DOC19/910196
SSI 8583

Re: Request for advice on Powering Sydney's Future State Significant Infrastructure project (SSI 8583)

The EES Group has reviewed the Biodiversity Development Assessment Report (BDAR) and provides the following advice. Please note that as spatial data was only provided for vegetation areas, consistency of the BDAR with any other spatial layers could not be examined.

Figure 17 | Location of Turpentine-Grey Ironbark Forest PCT

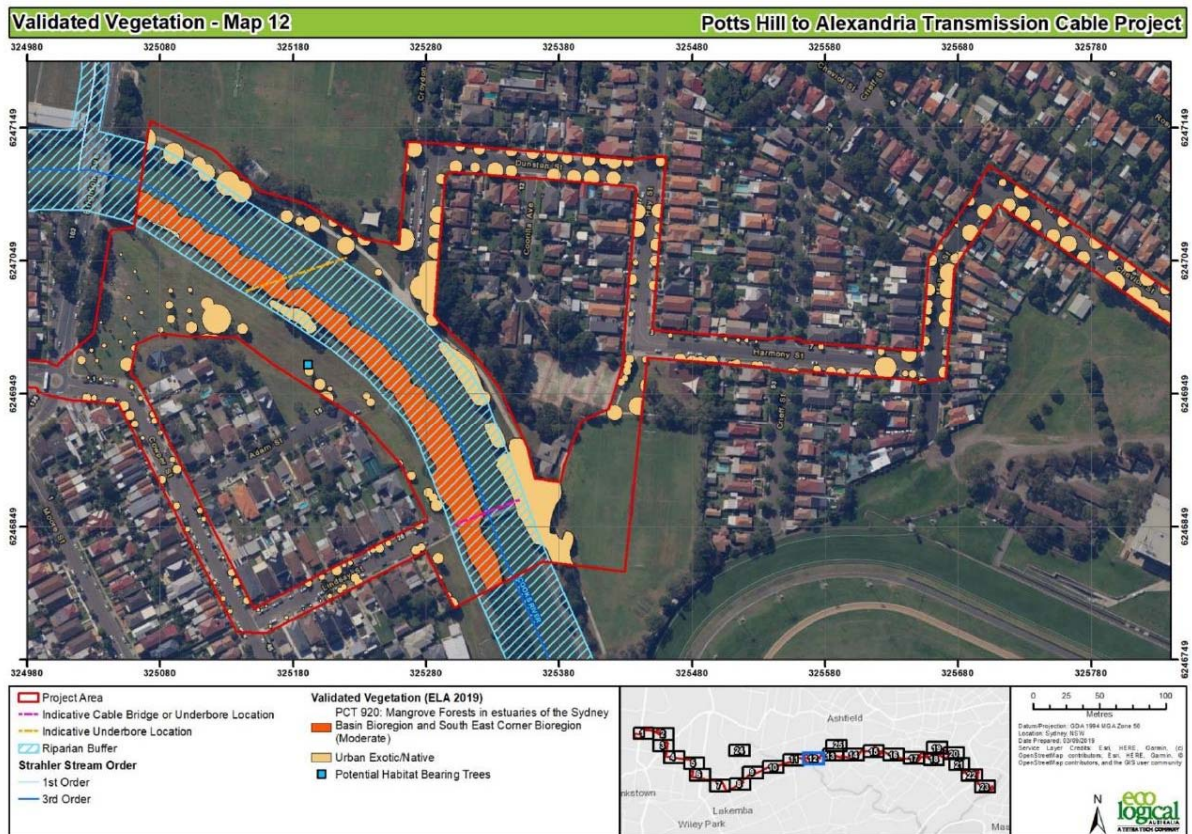
1.4.1.2 PCT 1281 Sydney Turpentine-Grey Ironbark Open Forest on shale in the lower Blue Mountains and Sydney Basin Bioregion (unvalidated)

- The BDAR identifies an area of native vegetation within the project area at Johnson Park within the Dulwich Hill light railway (DHLR) corridor. It is noted that this vegetation is the result of 19 years of bushcare work by the Inner West Environment Group to revegetate the site using '*over 100 different native plant species found in Sydney Turpentine-Ironbark Forest (STIF)*' critically endangered ecological community (www.greenway.org.au/biodiversity/bushcare/bushcare-sites). While this vegetation is assigned to PCT 1281 'Sydney Turpentine-Grey Ironbark Open Forest on shale in the lower Blue Mountains and Sydney Basin Bioregion (unvalidated)' as a best fit PCT, the BDAR considers it unlikely '*that (the) vegetation ... would meet the TEC STIF criteria, as the vegetation consists of planted rather than remnant vegetation and lacks a canopy*' (BDAR, p.21). It is noted the assessment of this area was '*based on distant visual assessment and on a desktop review of plant listings of the Johnson Park Bushcare site*' as '*no quantitative survey was undertaken*' because the site '*could not be accessed during the survey due to its location within the DHLR corridor*' (BDAR, p.20). This is despite more than 18 months between the first vegetation surveys and finalisation of the BDAR.

- EES Group is not aware of any criteria that would preclude such vegetation being classified as a TEC and does not concur with the rationale for not assigning this area of PCT 1281 vegetation as a threatened ecological community.

- Table 18 advises '*the project will avoid clearing at the Johnson Park Bushcare site (which has been planted with native vegetation) by underboring under the light rail corridor in Dulwich Hill*' (DBAR, p.65). The BDAR identifies this PCT vegetation as '*vegetation not requiring assessment*' (DBAR, figure 54, p.86). However, details of the proposed underboring are not described, nor are any indirect impacts considered in the assessment. It is recommended the potential impacts of the proposed underboring on this PCT vegetation be further assessed.
